DEVELOPMENT REVIEW BOARD – SPEED MEMO

DRB CASE NO: 1009604

SUBDIVISION DESIGN VARIANCE

City Project No. 655110  
 Zone Map No. E-5 & E-6  
 Sheet C-001 of #/##

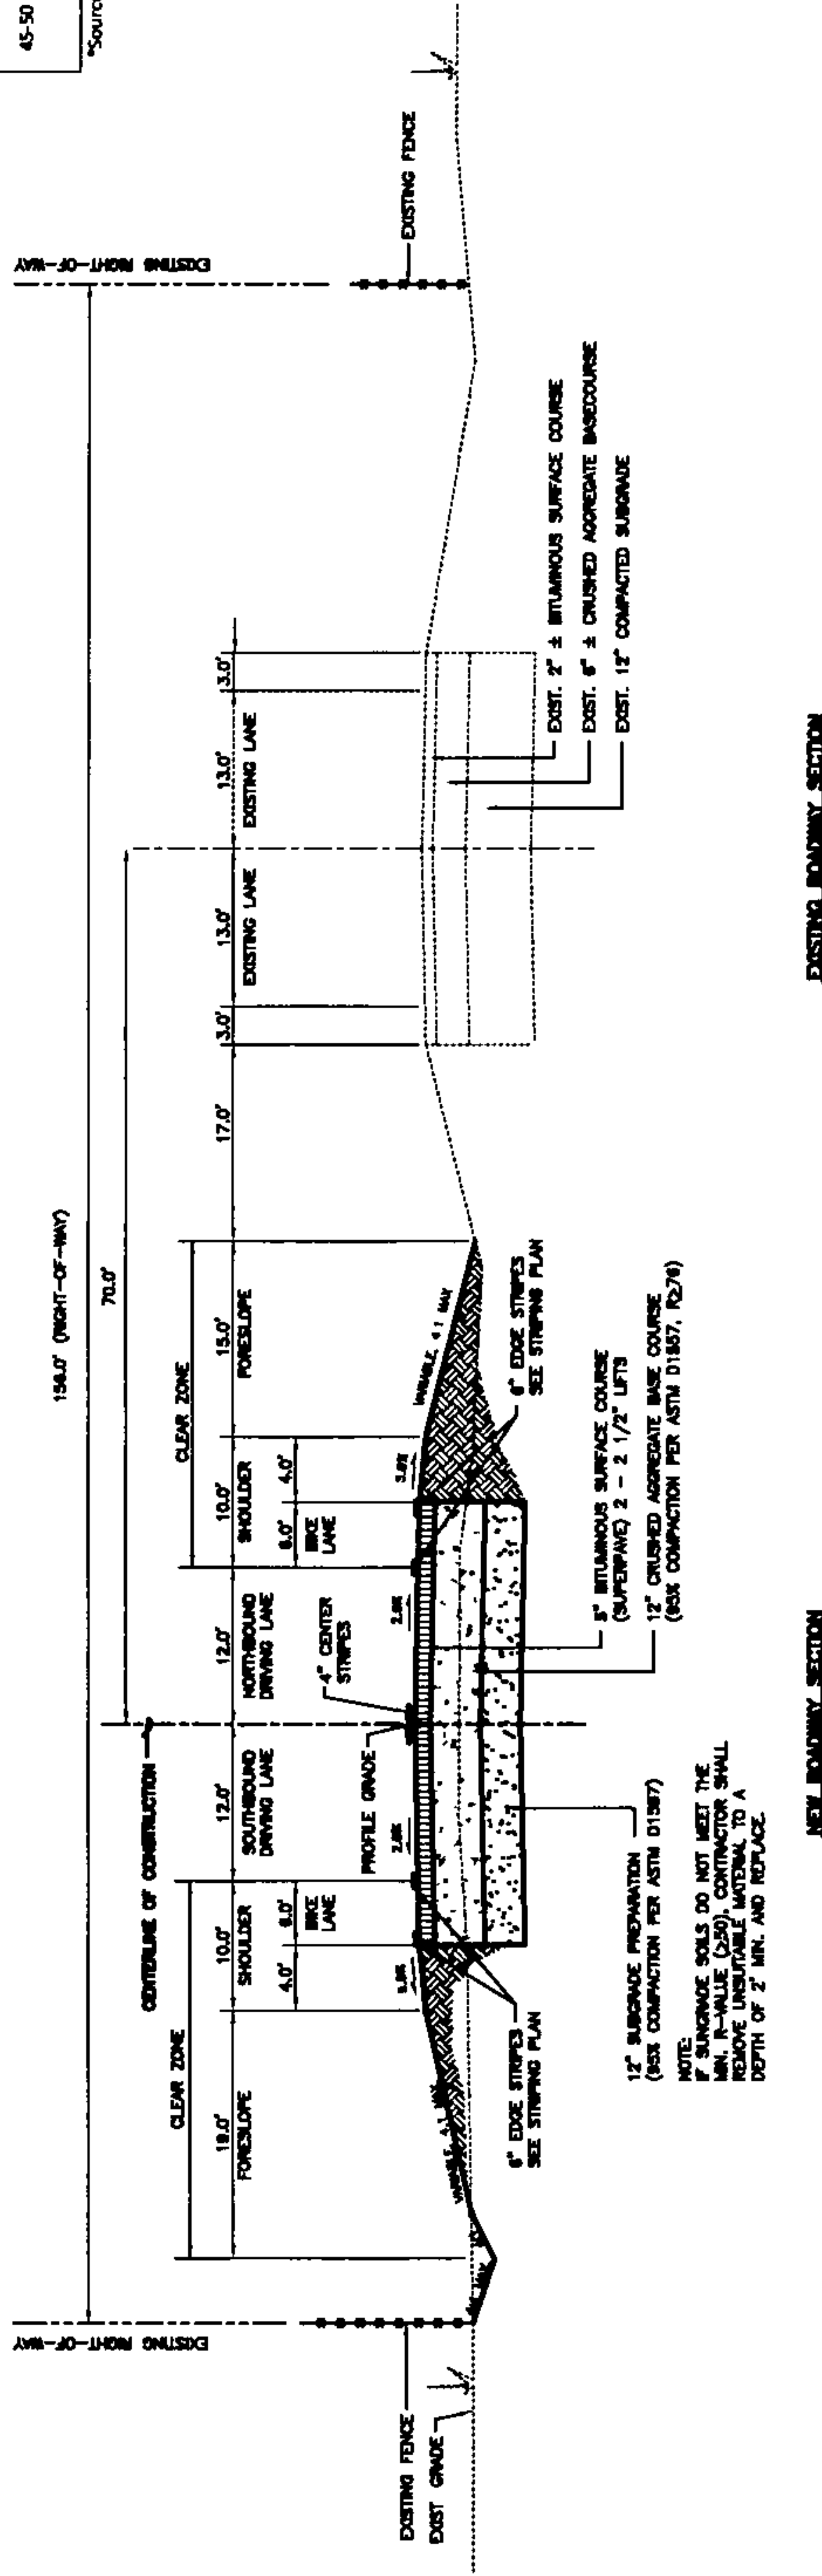
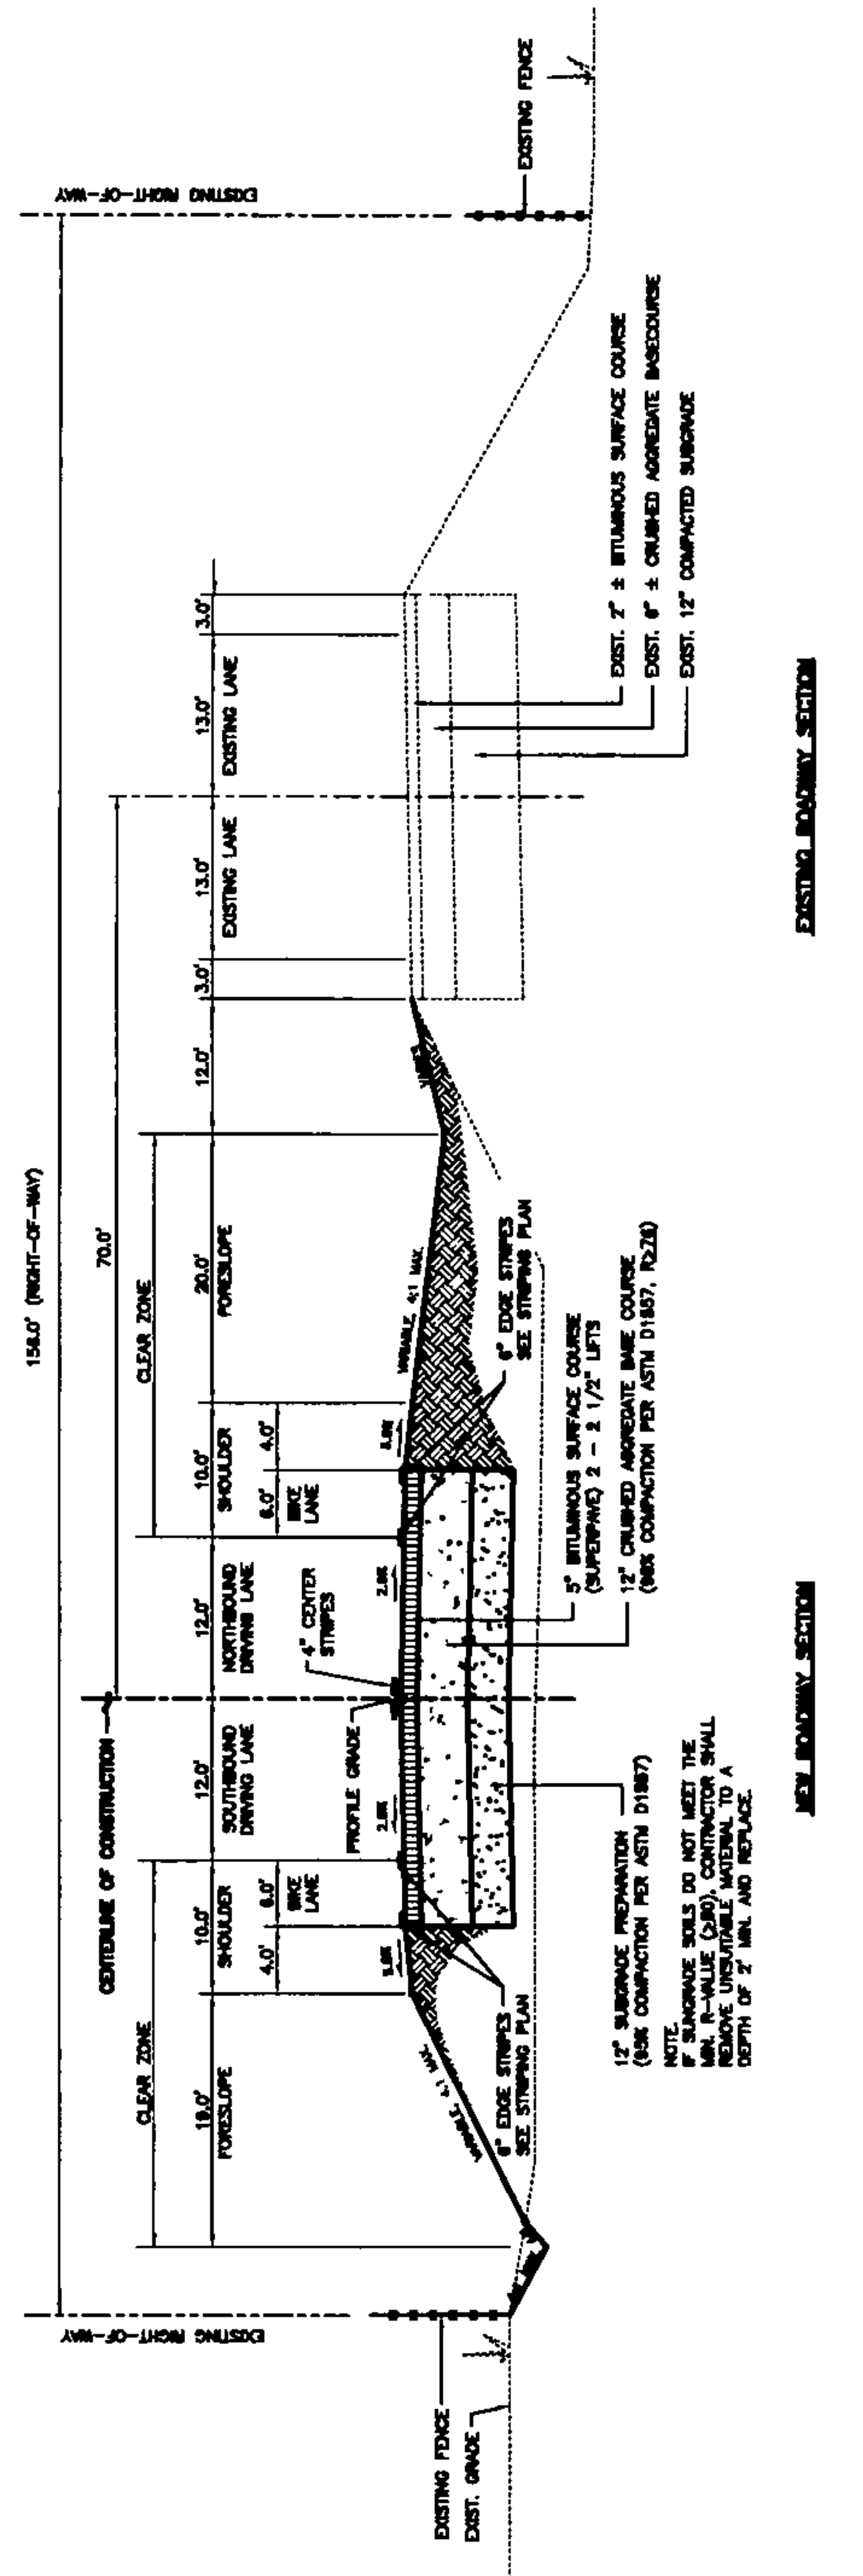
Clearly define what variances are being requested: street lights, curb and gutter, sidewalk, pavement design, etc.

Justification must be provided.

The letter provided indicates that curb and gutter and sidewalk may be required at a later date. If this is the case, a variance would not be appropriate.
